Application for Approval of Reserved Matters (Appearance, Landscaping, Layout and Scale) following Outline Planning Permission (OPP) AL/178/22/OUT (Appeal: 6312).

Submission of Substitute Plans to Address Consultee Comment

Land to the Rear of Meadow Way, Westergate | AL/35/26/RES

Drawing Title:
Impermeable Area Plan

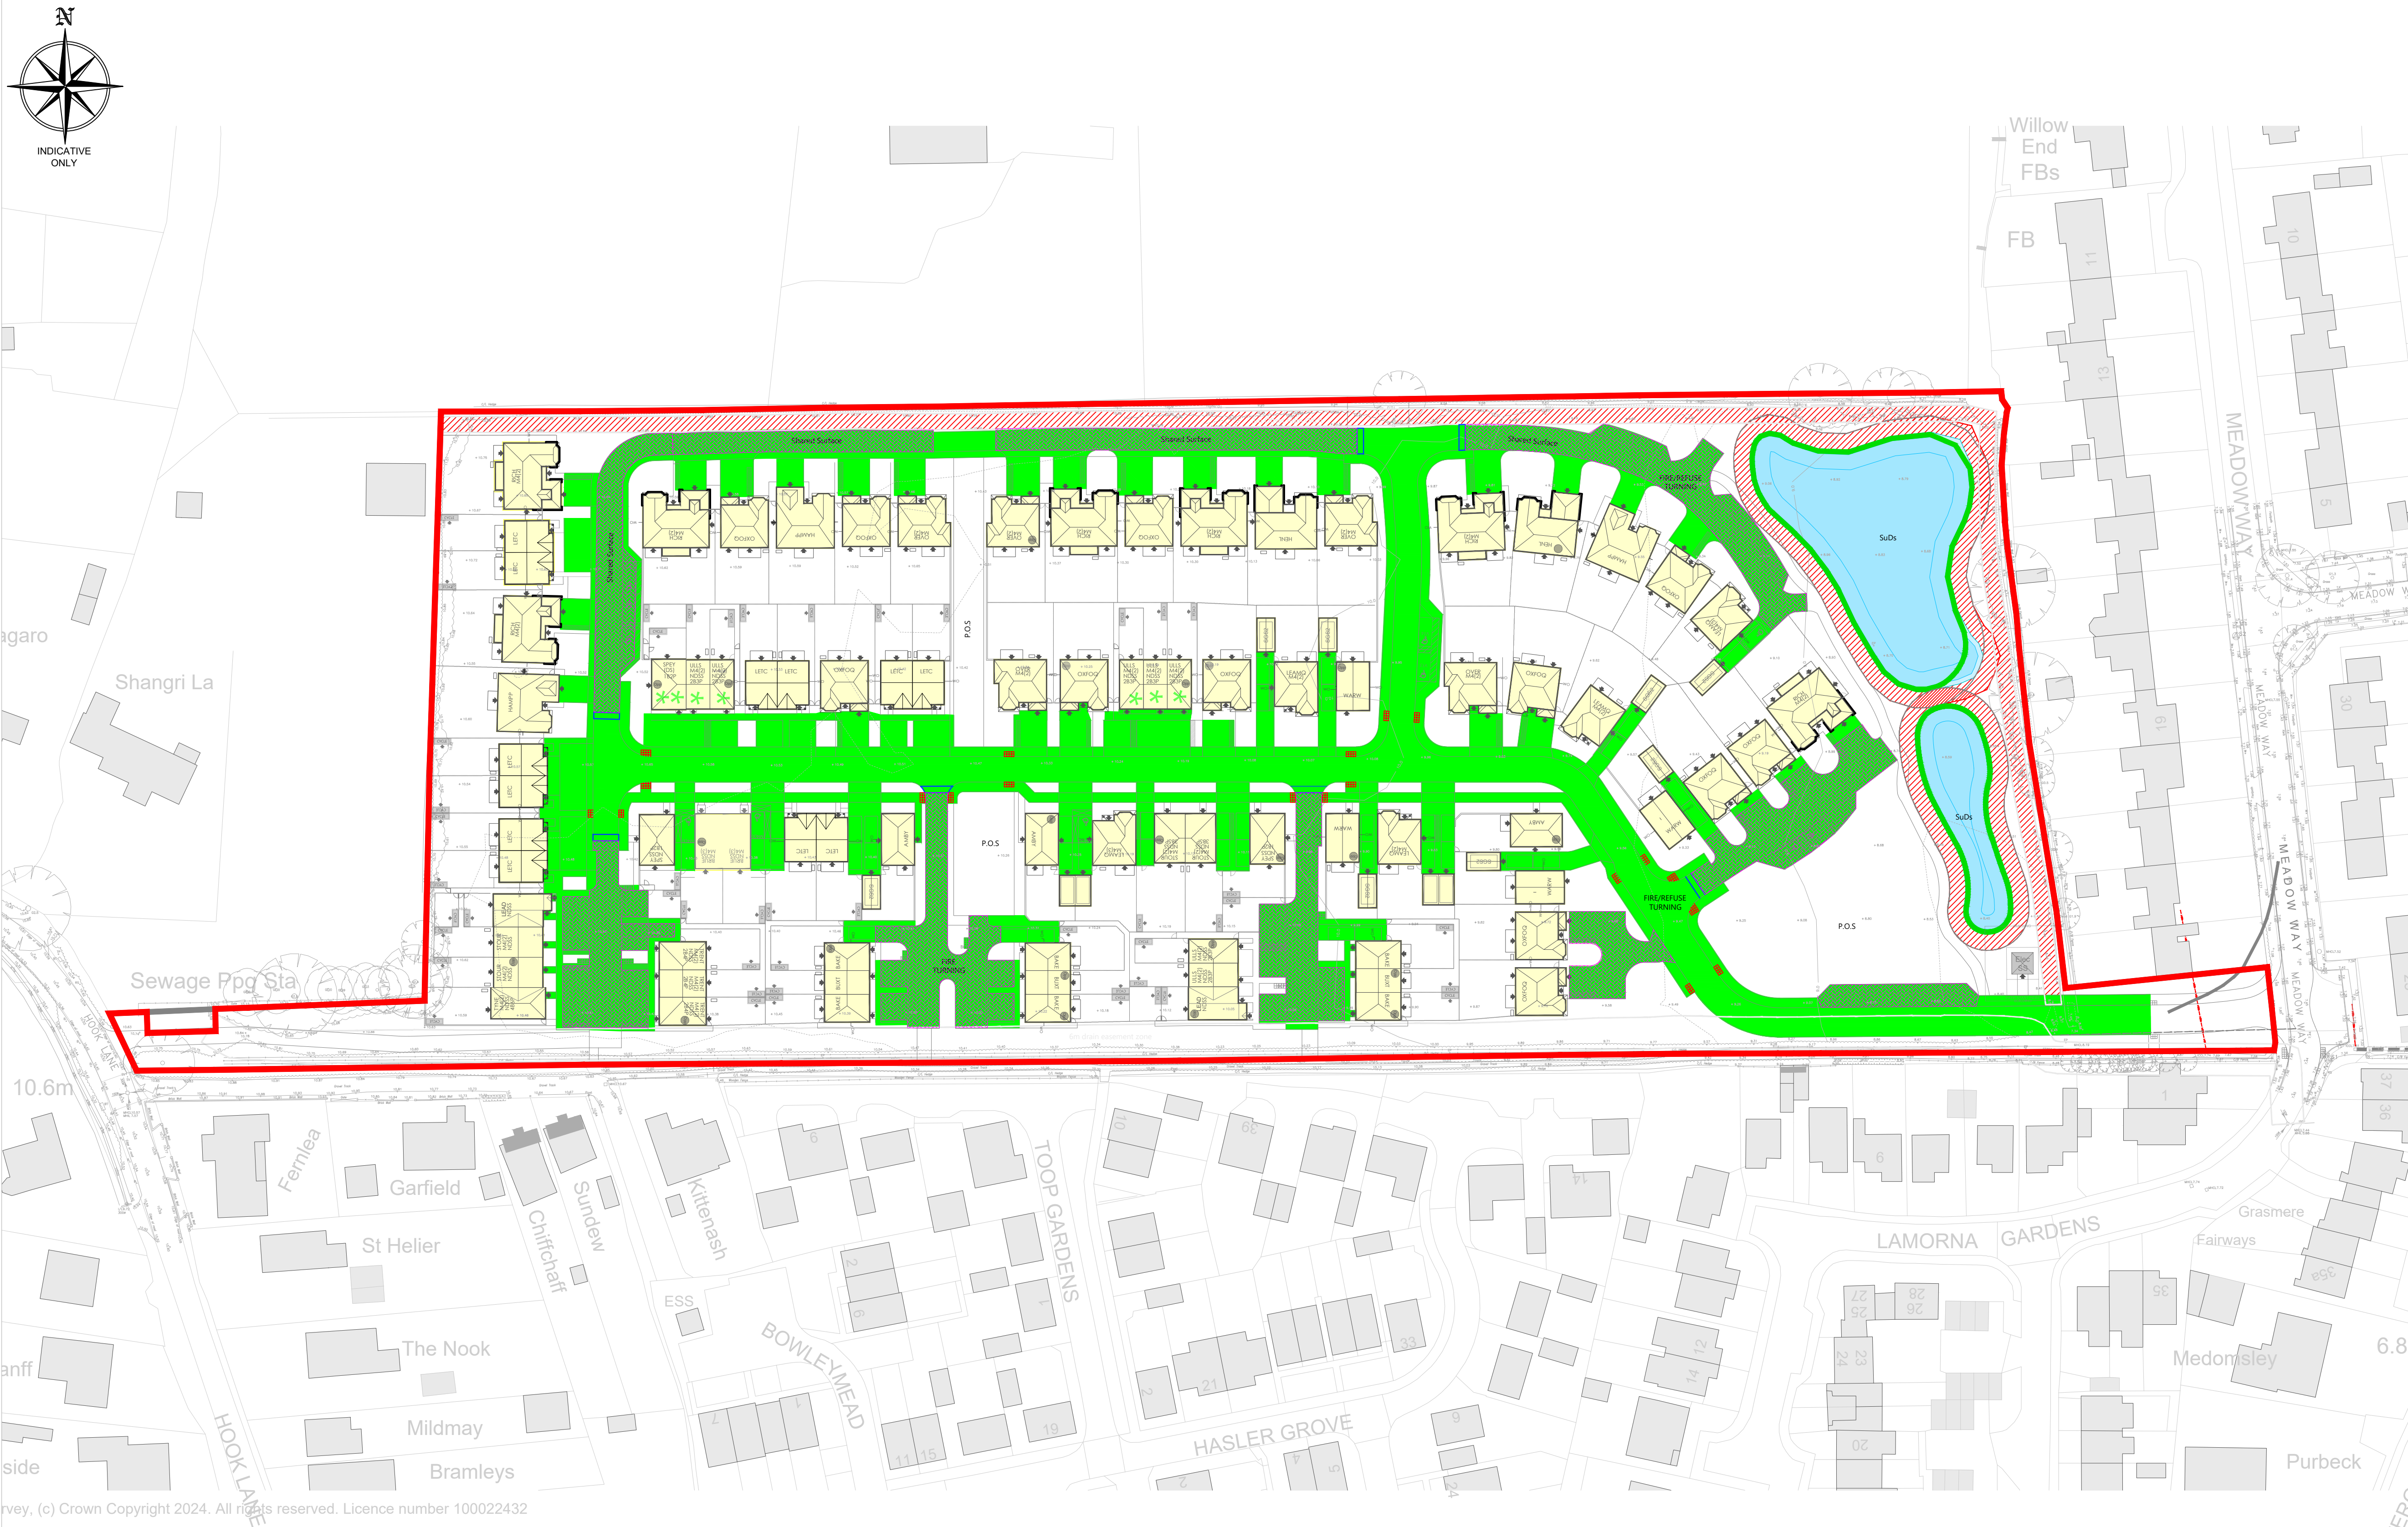
- Tactile paving has been provided at all appropriate pedestrian crossing locations;
- Granite setts have been introduced, where required, to clearly delineate the transition into and out of shared surface areas; and
- The extent of the footways has been adjusted accordingly, directing pedestrians to enter shared surface areas behind the line of granite setts.
